## 25 alderbrook peaks island

**Chris Coppi** <chris@albertfrick.com>  
To: ppeters270@aol.com  
Cc: amachado@portlandmaine.gov

Fri, Jul 21, 2017 at 1:19 PM

**SITE PLAN AND  
BOUNDARY SURVEY OF LAND AT  
25 ALDERBROOK ROAD, PEAKS ISLAND  
PORTLAND, MAINE**

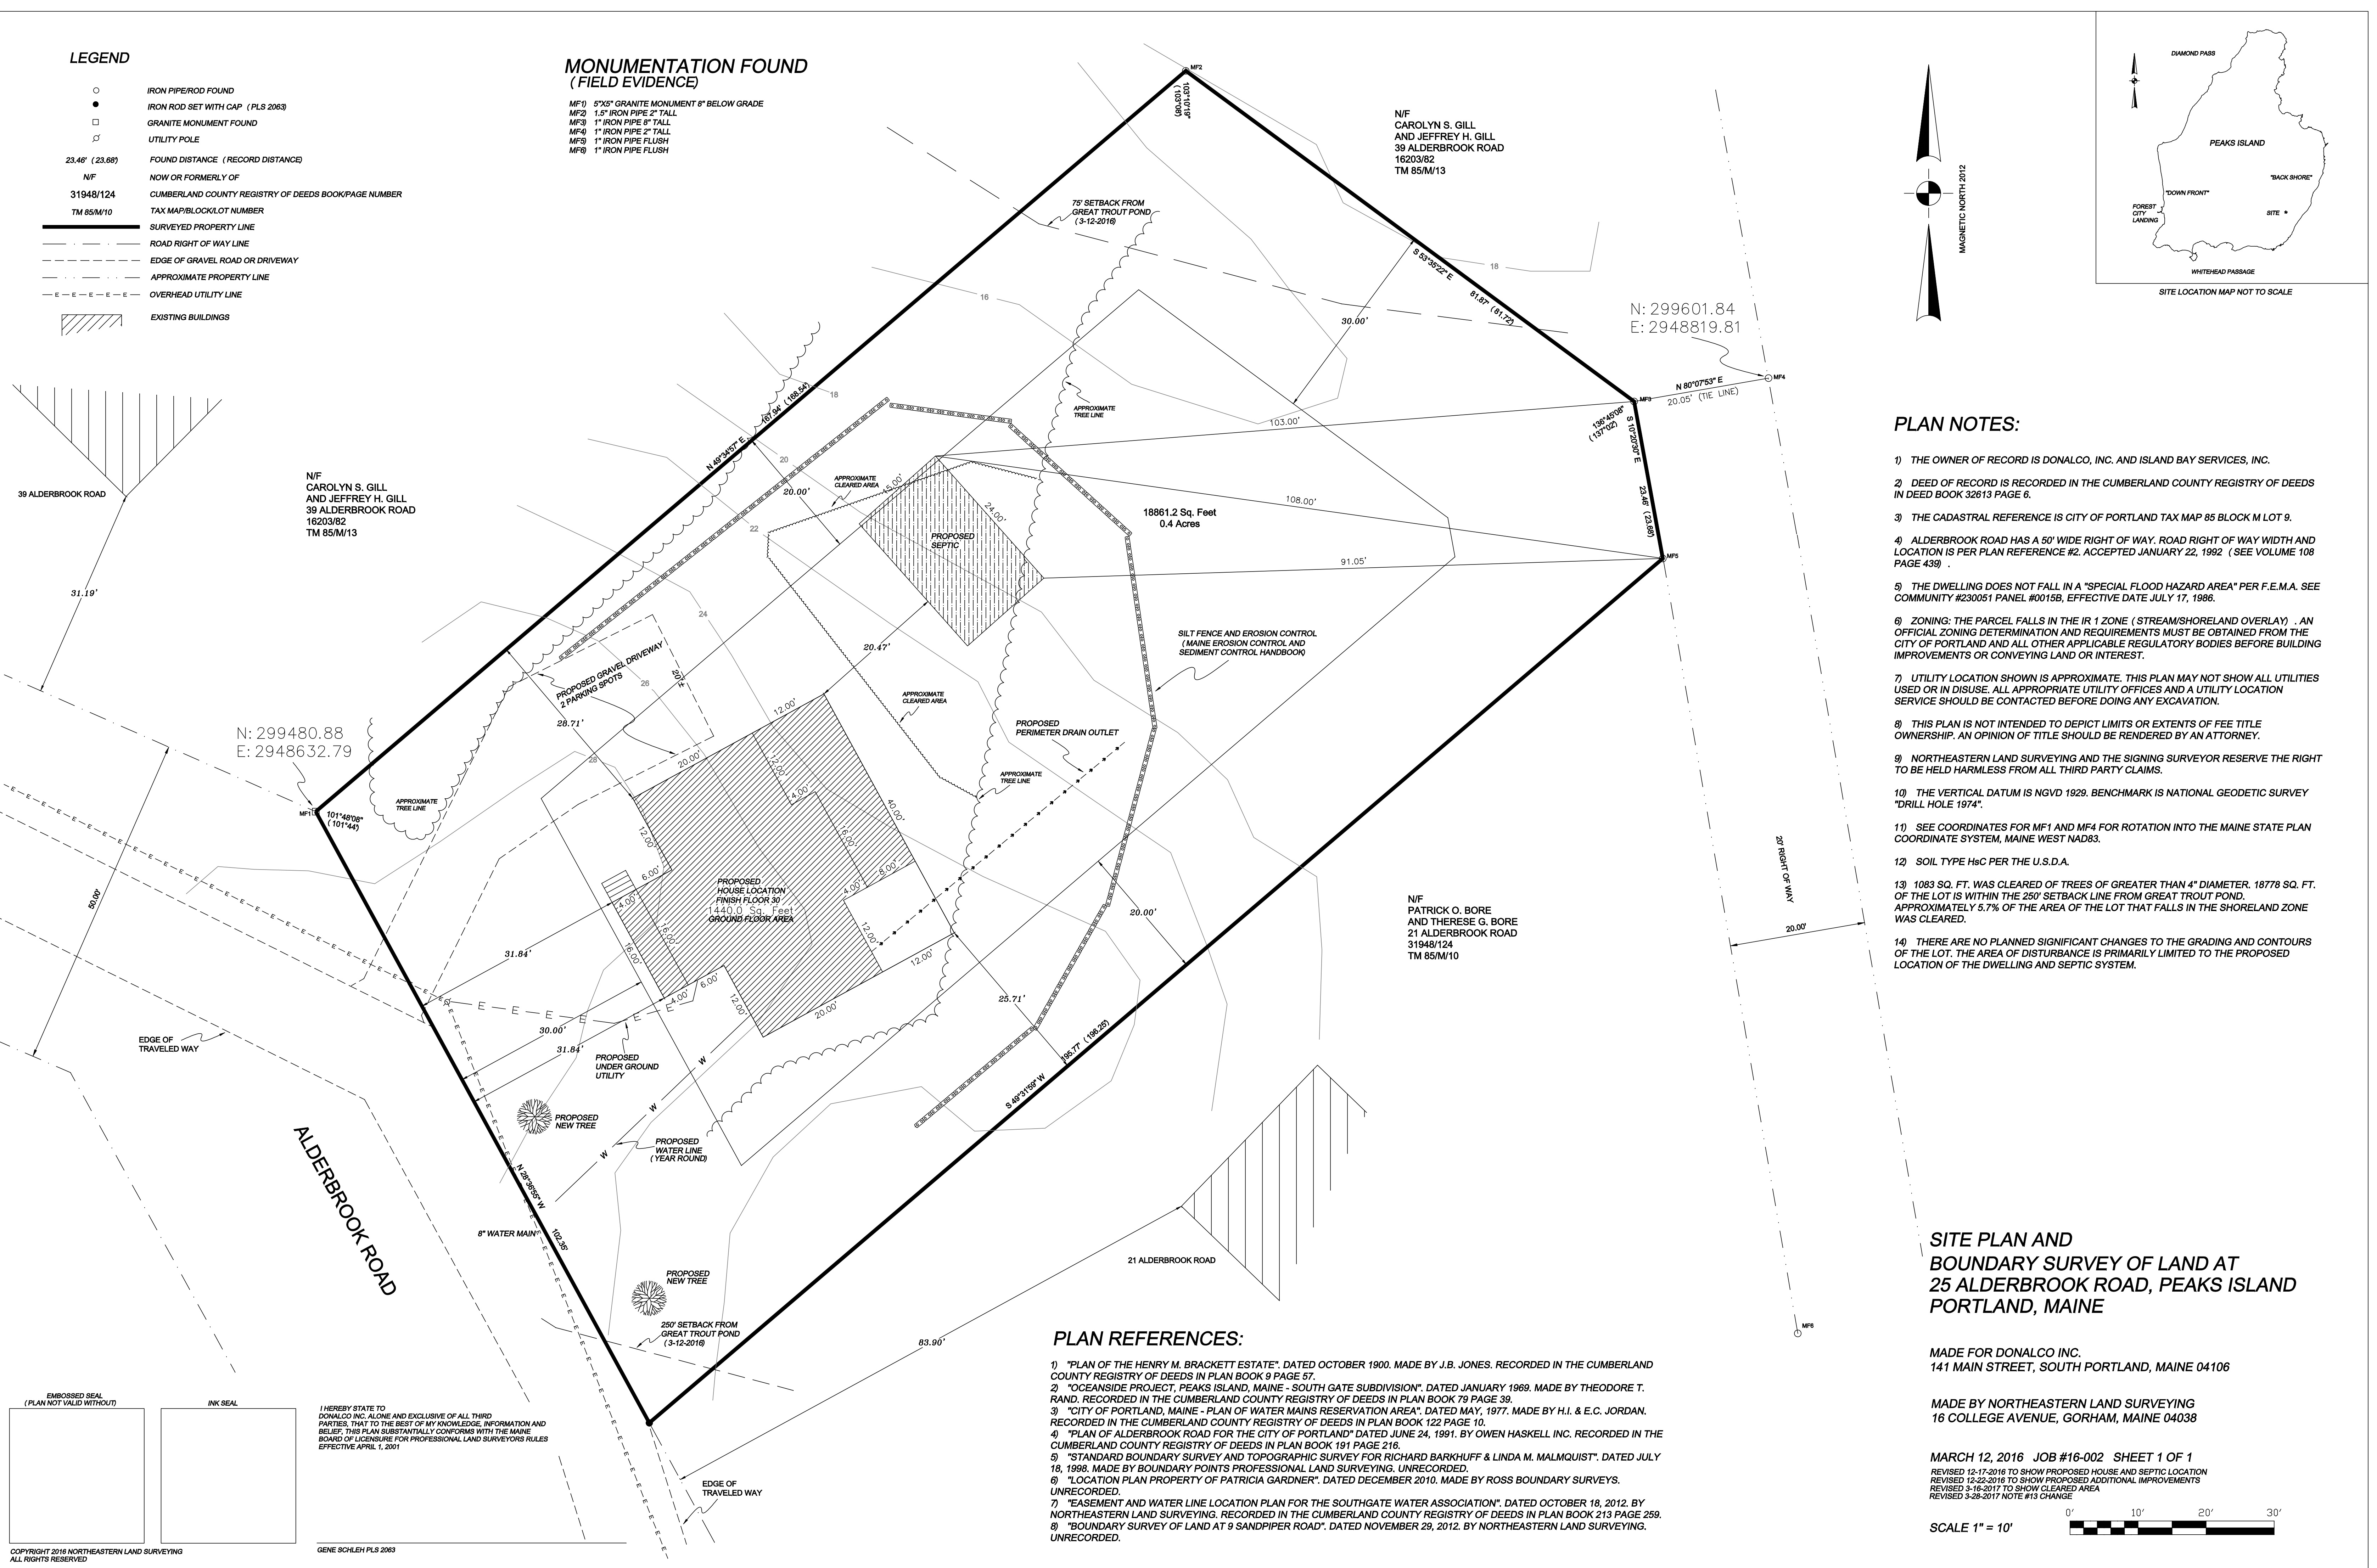
1. There were approximately 14 (total of 172 DBH) trees removed: (DBH= Diameter at breast height)

(Approximately 67 trees with varying DBH's remain and in terms of volume, appear to meet the maximum 40% volume based on the total DBH of trees in the non cut area (407 total DBH) vs. the area cut (172 Total DBH).

2. 2" tree saplings are proposed
3. The house will be 32 by 40 and the driveway leads to the edge of the house in between two restored areas. I can update the plan and send it over to you with a call out text for the driveway.

The lot appeared to be infested with non-native invasive plant species throughout the cut area and the area that wasn't cut. I found Japanese barberry, honey suckle, and blackberry (native but invasive). This likely resulted in a low coverage of understory and ground cover on the entire lot. We are proposing to supplement the trees species with both ground cover and shrubs as noted on the plan. The result will be an improvement with native plantings in the areas to be restored.
